City of Albuquerque

September 25, 1990

RE: DRAINAGE PLAN FOR RITE WAY ROOFING
(J-14/D92) RECEIVED SEPTEMBER 18, 1990

DRAINAGE PLAN
1"=10.0'

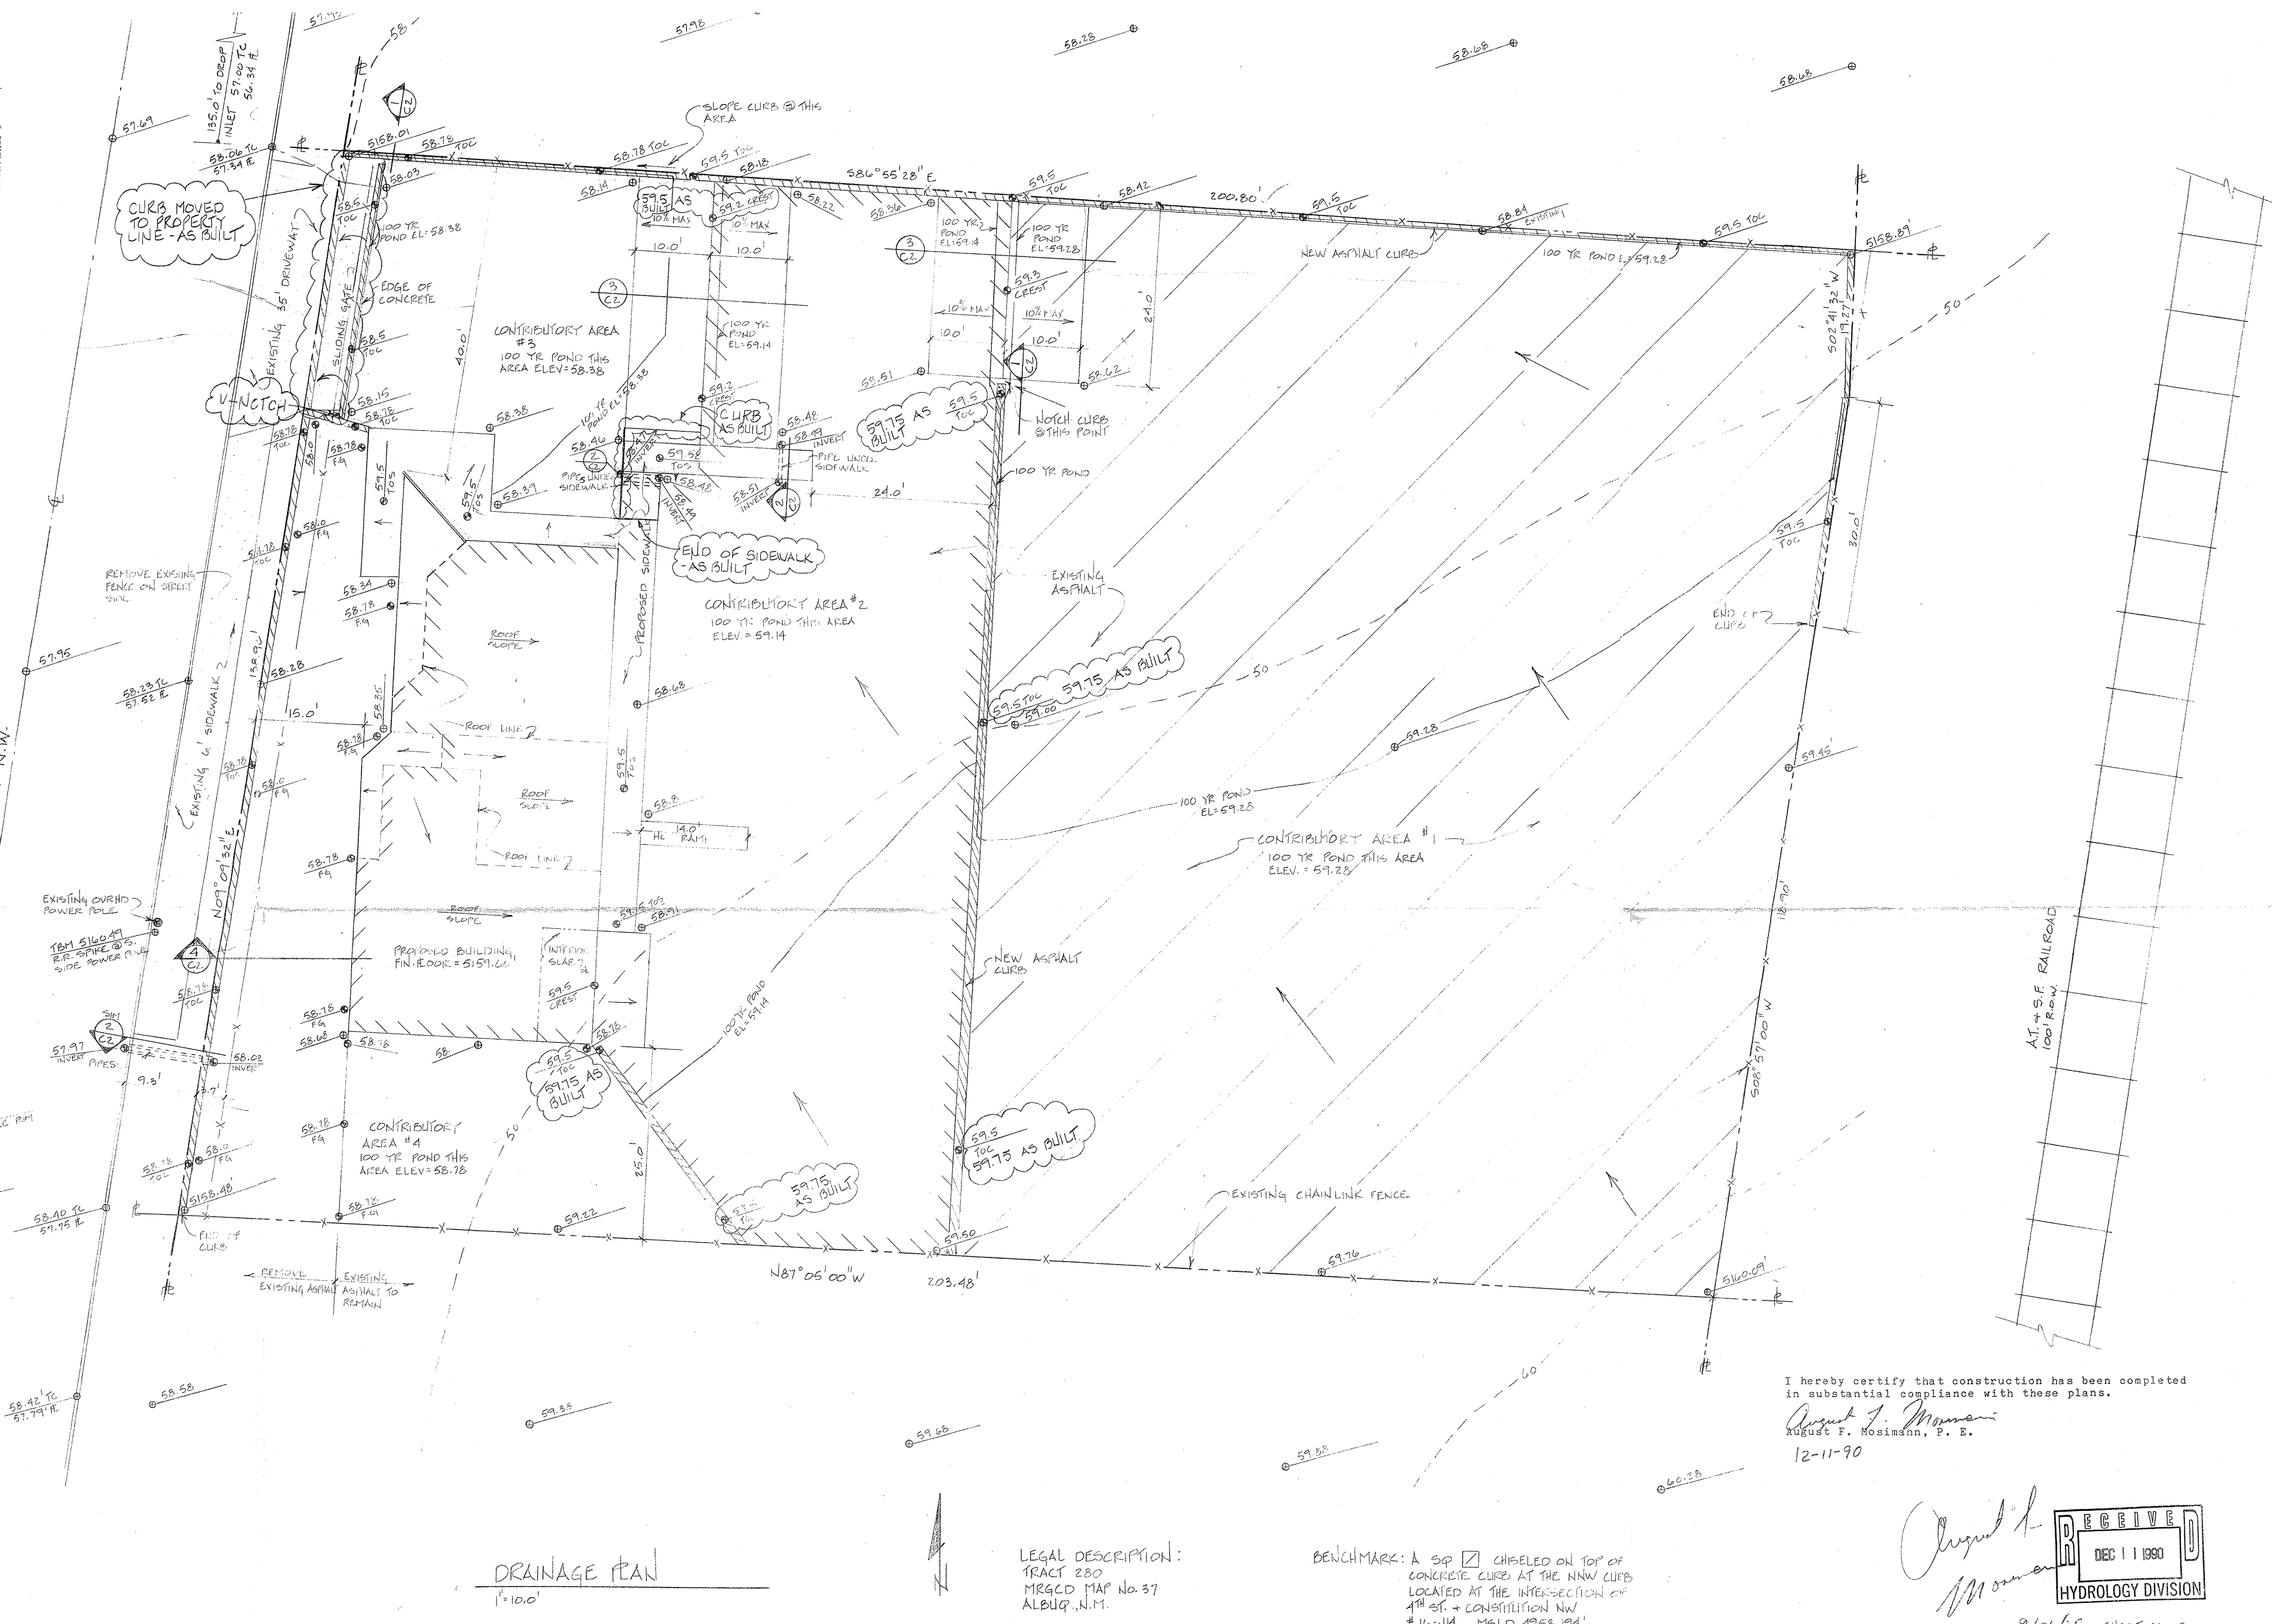
1. Use the orifice equation to determine the flow of your proposed pipe. You will need to design for either 4" pvc pipes or a sidewalk culvert. A 6" pvc pipe is not allowed per the City Standard Specs.
2. Please identify the emergency spillway for each basin.
3. Please use the weir equation to compute the proposed V-notch on the curb.
4. Because of the ponding requirements, Engineer's Certification will be required prior to Certificate of Occupancy release. Certification must be done per the DPM Engineer Certification Checklist.
5. You must also include the six notes from the S.O. #19 format along with the sign-off blocks within the plan drawings. Two copies required with the resubmittal.
